Rezoning Transportation Analysis

Petition Number: 2023-124

Date	Description
11-21-23	First Review (IW)
12-19-23	Second Review (KC)
01-22-24	Third Review (IW)
02-21-24	Fourth Review

**RZ-1.0**

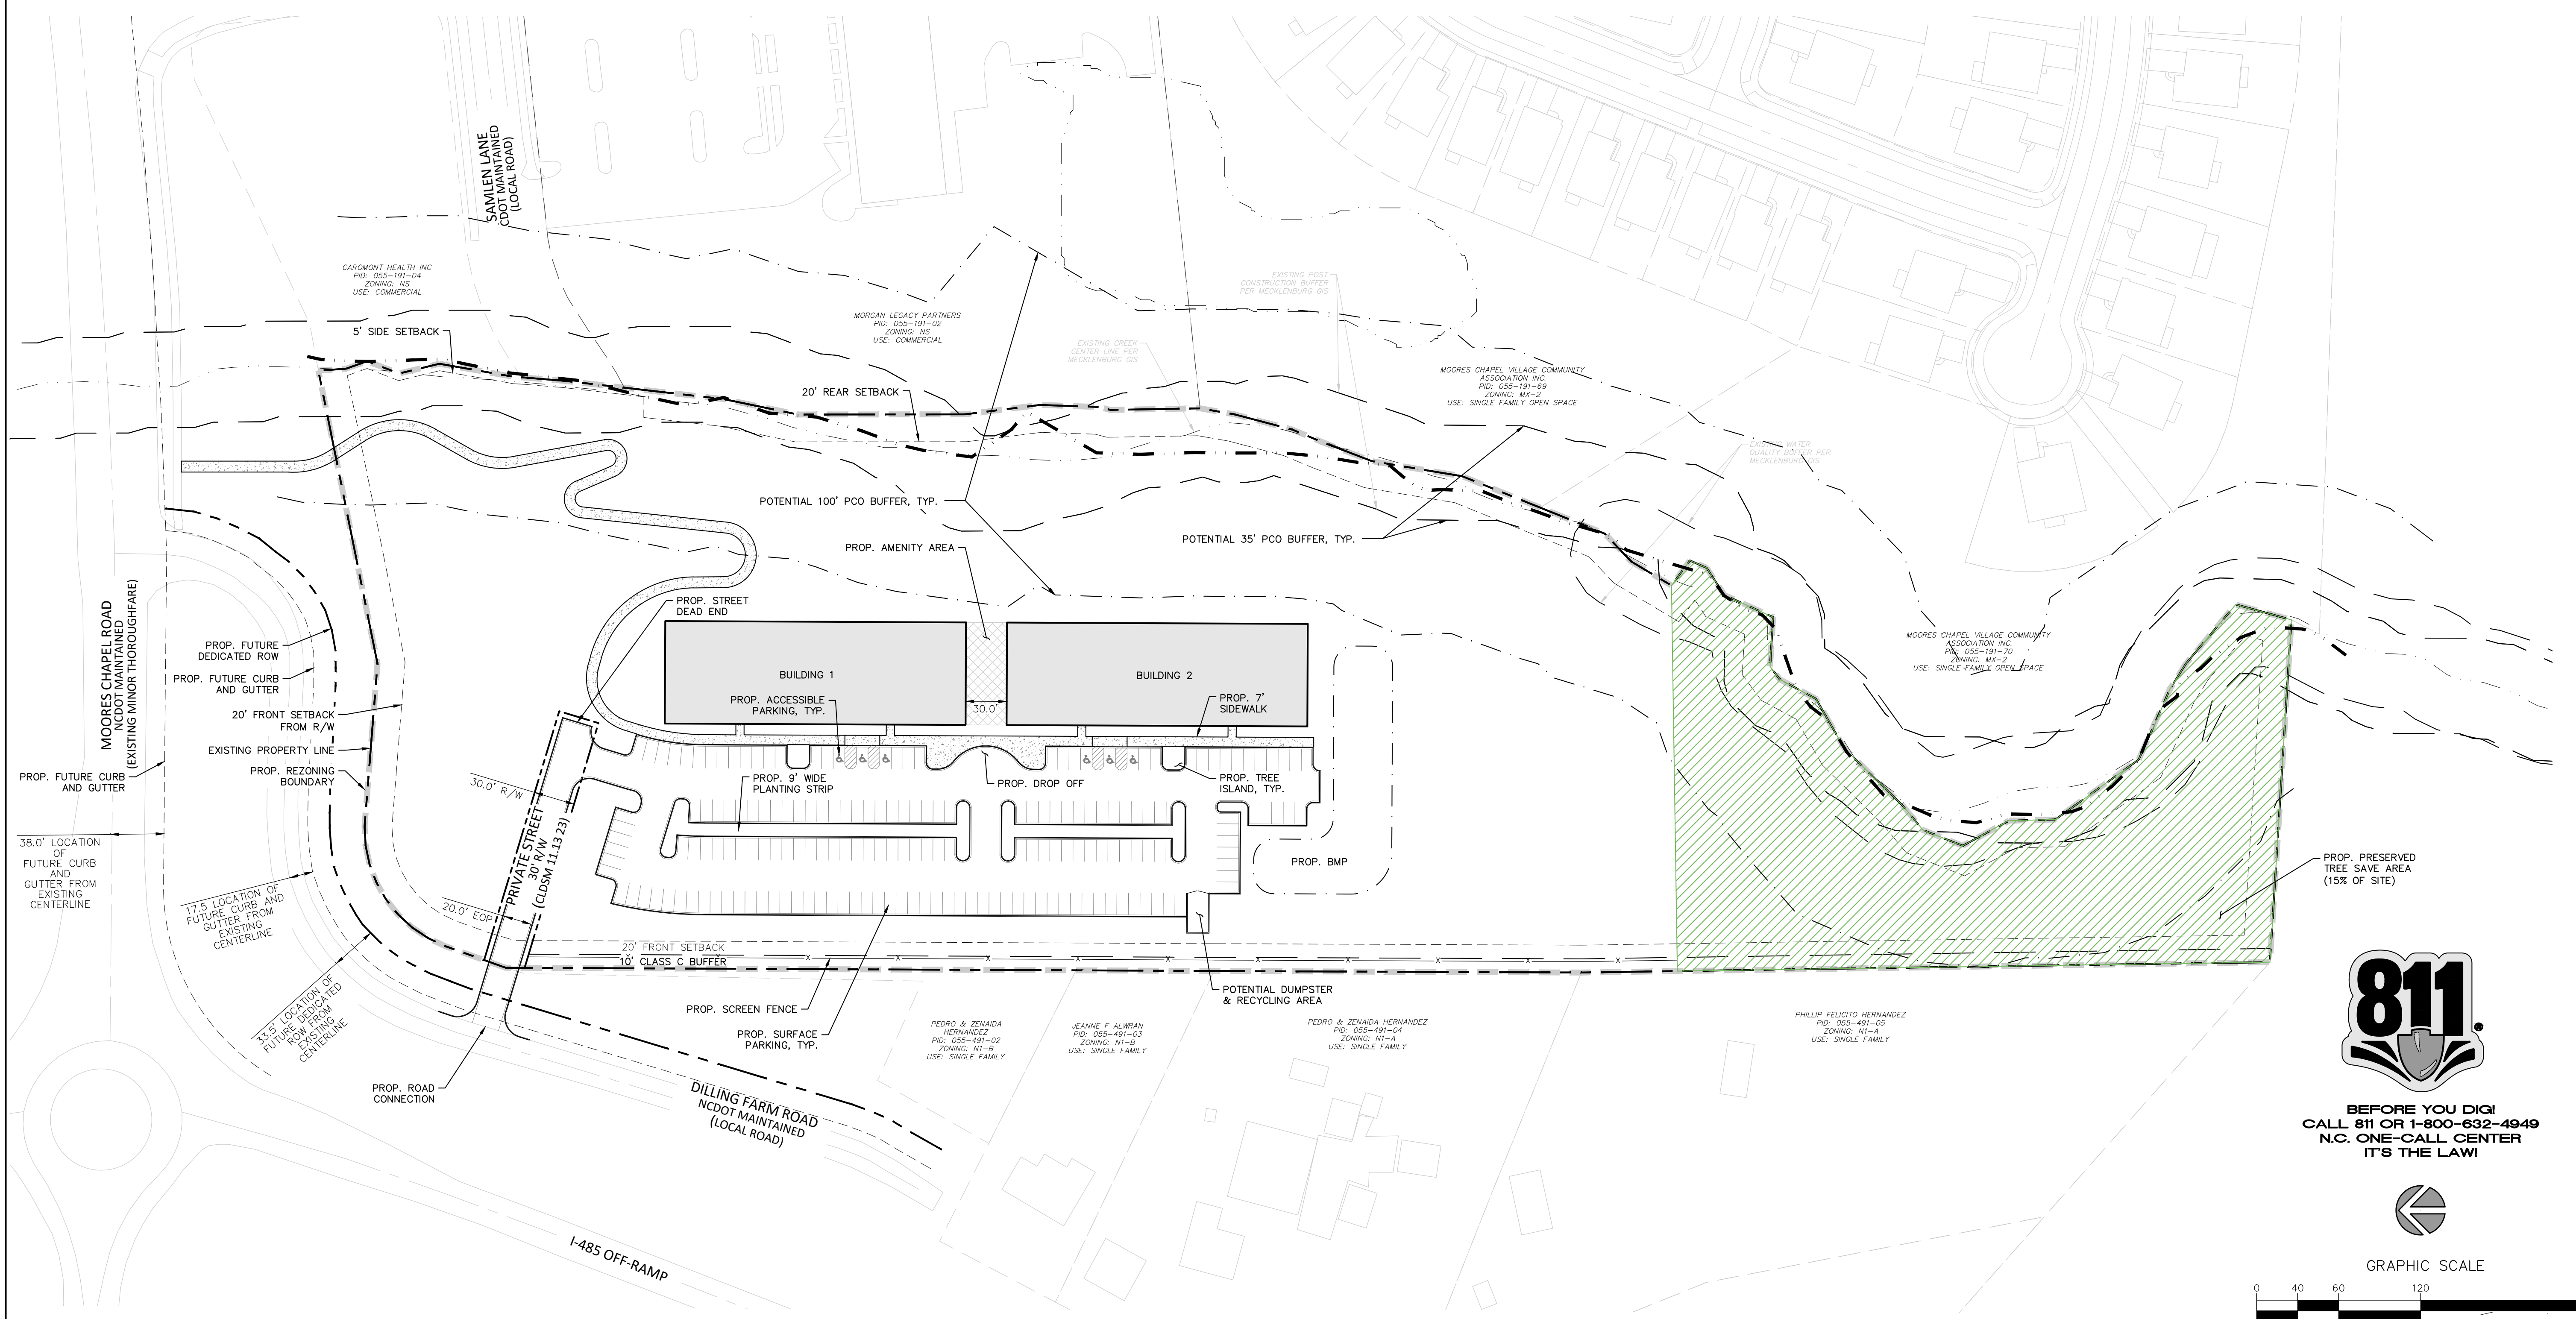
a. ~~**Moores Chapel Road:** Label and dimension the location of future curb and gutter to be 38' from centerline.~~

b. ~~**Dilling Farm Road:** The location of the future back of curb and gutter to be 17.5' from centerline. The sight plan is to commit to installing as well.~~

~~Label and dimension the curb and gutter from the centerline for each road on the site plan.~~

3. ~~Revise site plan and conditional note(s) to commit to dedicate 33.5' of right of way from the road centerline along Dilling Farm Road. The site plan shall label and dimension the right of way from the road centerline.~~

5. ~~**Outstanding Comment 11-21-23:** Revise site plan and conditional note(s) to commit to constructing an 8' planting strip and an 8' sidewalk per Article 33 of the UDO and CLDSM U-03A1 along Dilling Farm Road.~~
~~**Clarifying Comment:** Site plan does not show 8' planting strip and an 8' sidewalk per Article 33 of the UDO and CLDSM U-03A1 along Dilling Farm Road.~~

6. ~~Revise site plan and conditional note(s) to commit to making "Public Road 1" a private road per coordination with Subdivision.~~
